Appendix B: Response to Council's recommended conditions

SITE PLAN

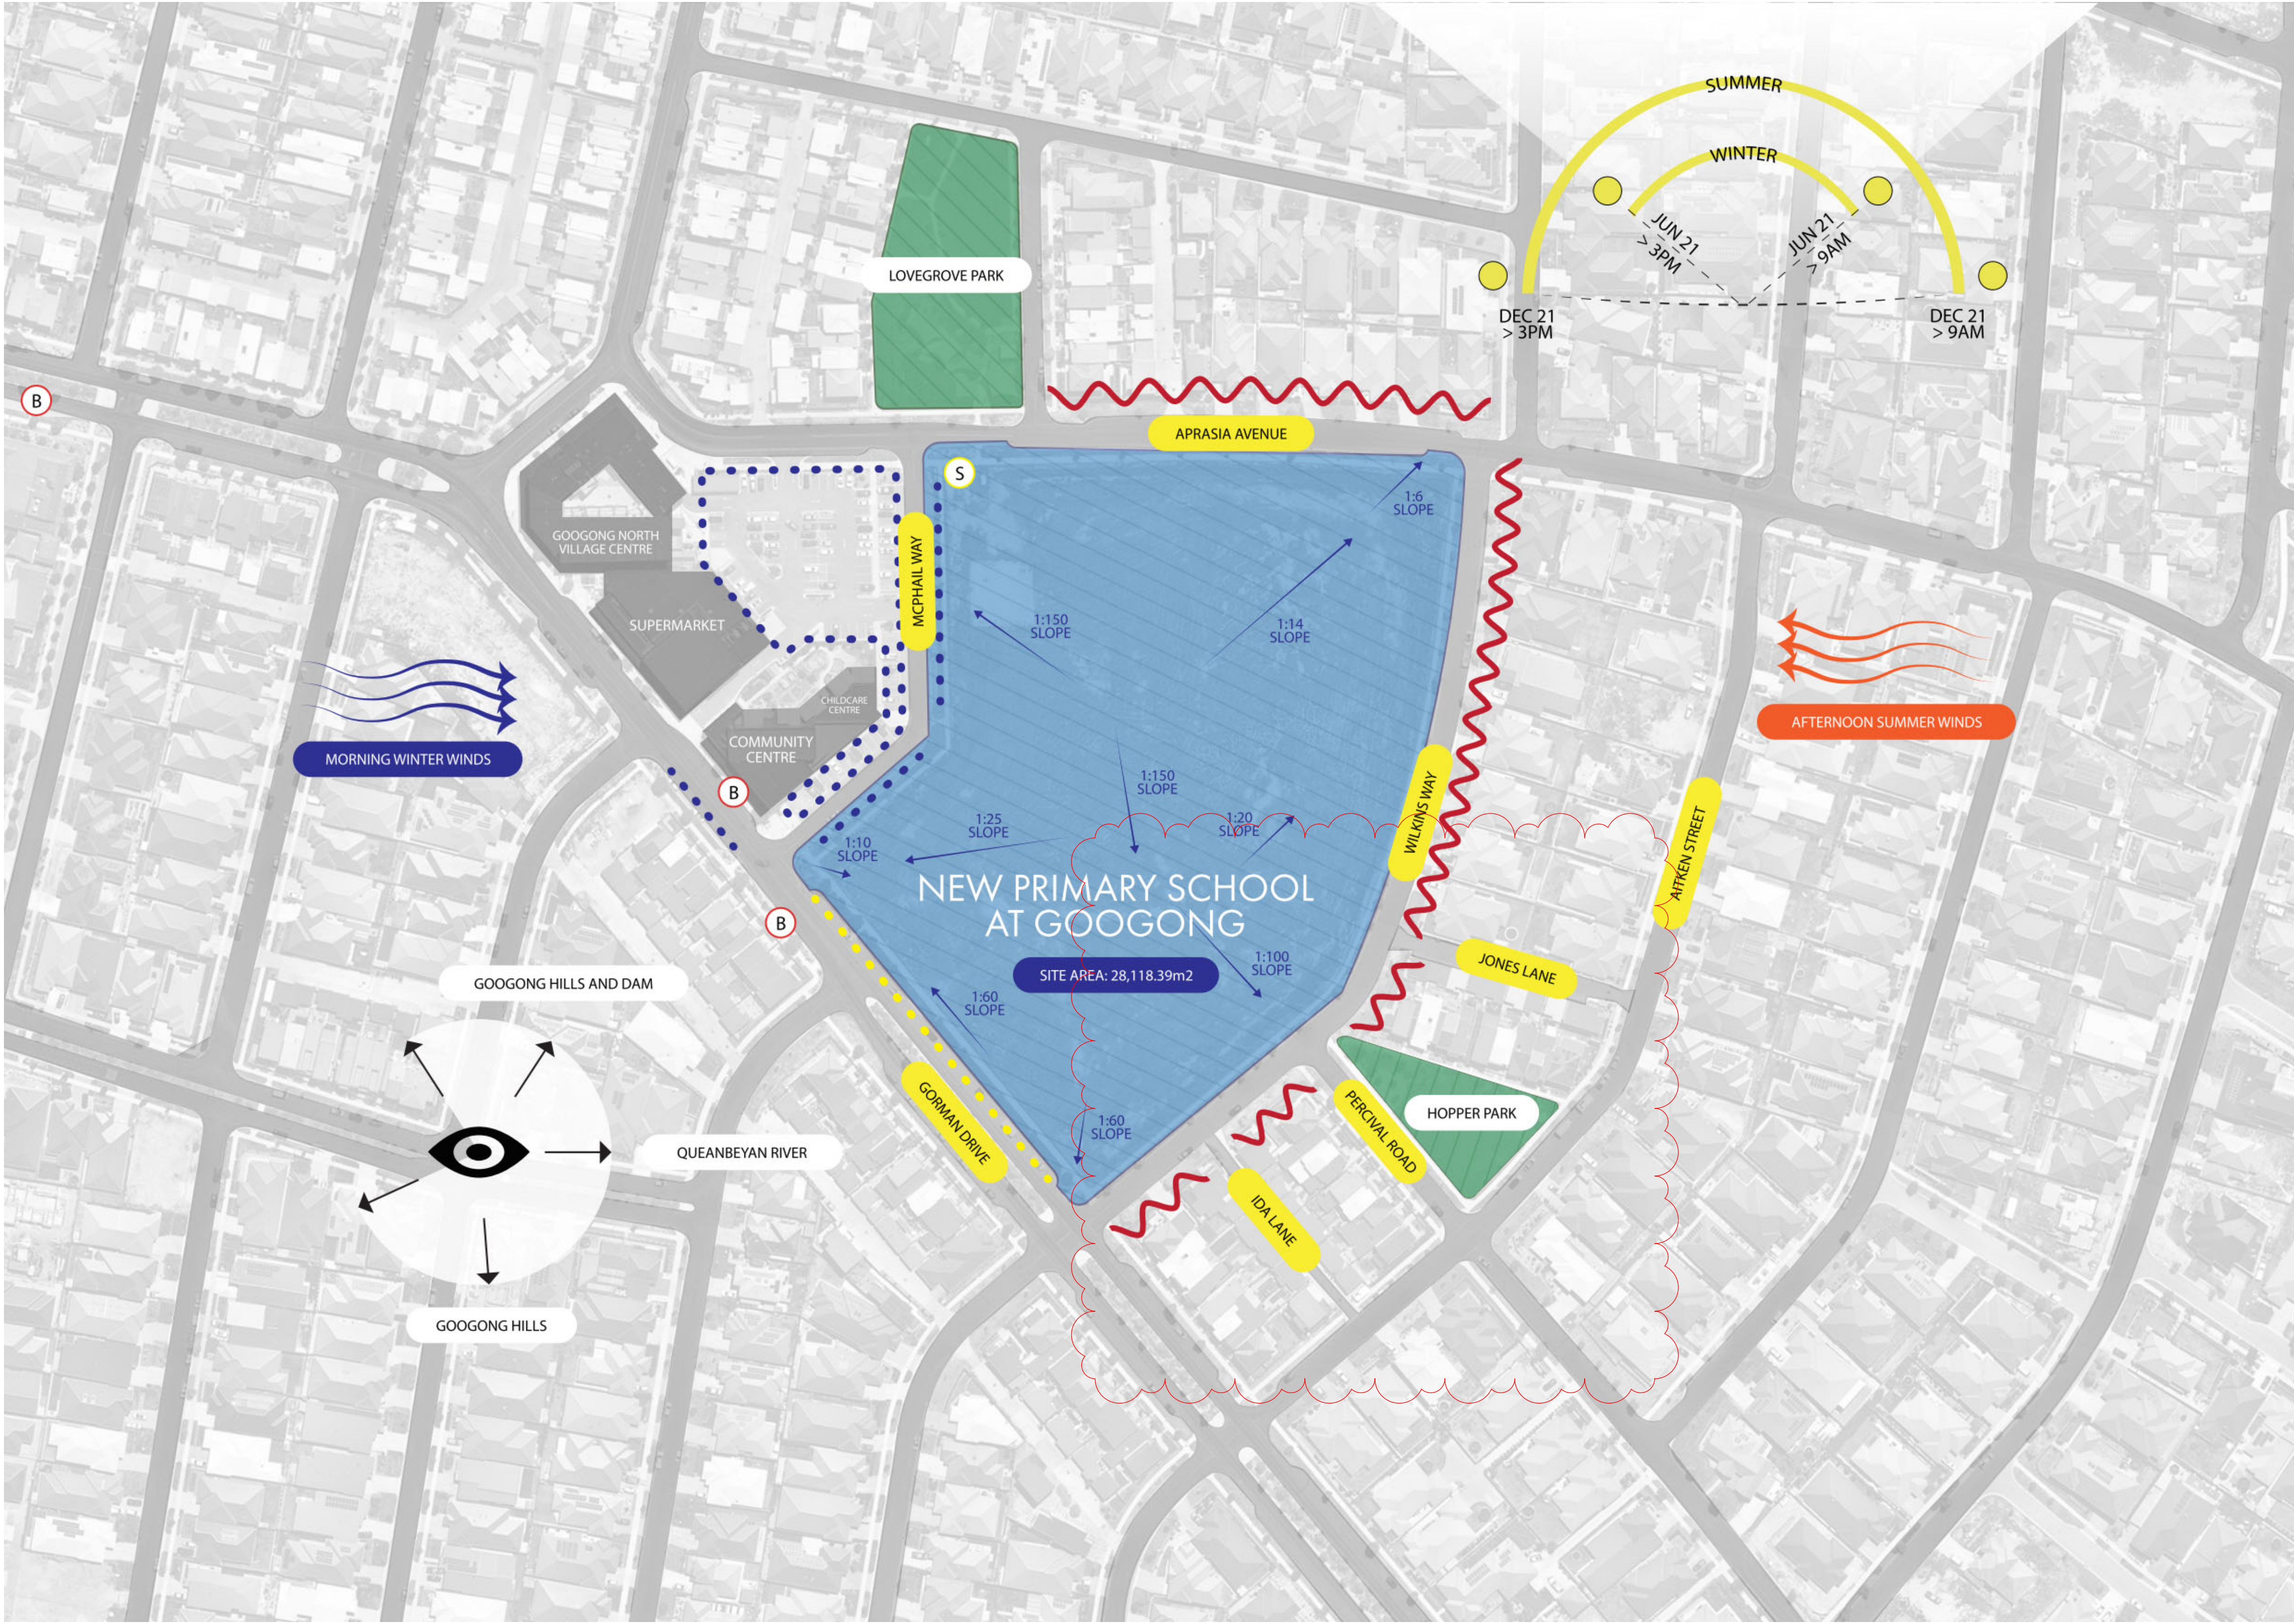
<p>Bus Bays</p> <p><i>The applicant should maximise the frontage of Gorman Drive to be utilised for the bus bay area with the exception of any pedestrian crossing that may be warranted.</i></p>	<p>The applicant does not support this condition for the following reasons:</p> <ul style="list-style-type: none"> • The bus bay area, including length, has been reviewed by TfNSW, and no comments were made in relation to the length. • The bus bay area was also reviewed by QCity, and no concerns were raised in relation to length.
<p>School Travel Plan</p> <p><i>Prior to occupation/use of the development as a school the NSW Dept of Education must submit a copy of the final School Travel Plan for Council's approval.</i></p>	<p>The applicant accepts DPIE's standard condition regarding the School Travel Plan, which requires preparation of the plan in consultation with Council.</p>
<p>Upgrade to Wilkins If Used as a Bus Route</p> <p><i>If Wilkins Way is to be used as a bus route it shall be reconstructed to</i></p>	<p>The applicant accepts DPIE's standard conditions regarding road works and section 138 approvals, which require the roadworks to be carried out to the satisfaction of the</p>

<p>Use of Pedestrian Safety Fencing</p> <p><i>The applicant should consider the installation of fencing to direct pedestrians to the correct crossing points and away from the potential mid-block crossing point on McPhail Way.</i></p>	<p>The applicant accepts this condition.</p>
<p>Section 138 Consent & Traffic Management</p> <p><i>Prior to undertaking any works within a public road reserve or affecting the road reserve, a traffic management plan is to be submitted to and approved by Council.</i></p>	<p>The applicant accepts this condition.</p>
<p>Car Park</p> <p><i>The car park is to be amended such that waste vehicles are able to pick up waste without carriage through parking spaces and the driveway is to be widened sufficiently that the check vehicle is able to enter and exit without tracking the kerb and verge.</i></p>	<p>The applicant accepts this condition.</p>
<p>General conditions</p>

<p>Privacy Treatments</p> <p><i>Permanent privacy measures are to be imposed to all second storey windows facing onto dwellings along Gorman Drive and Wilkins Way. Measures are to be a height of 1.7 metres above the adjacent finished floor level.</i></p>	<p>The applicant does not support this condition. Compliance with this condition would have a detrimental impact on the quality of the teaching spaces by reducing natural light. Also, as per our previous response on this issue, large separation distances and landscaping will effectively mitigate any potential privacy impacts. The school will be separated from the nearest residential lots on Gorman Drive and Wilkins Way by approximately 32.4m and 27.8m, respectively. These are substantial distances that avoid any need for privacy treatments.</p>
<p>Acoustic Treatments</p> <p><i>Acoustic treatments are to be imposed onto windows and building materials specifically adjoining Aprasia Avenue and Gorman Drive as per recommendations within the Acoustic Report prepared by Pulse White Noise Acoustics Pty Ltd detailed on pages 34 – 37.</i></p>	<p>The applicant accepts the content of this condition though expects the same outcome to be achieved by DPIE's standard conditions regarding acoustics.</p>
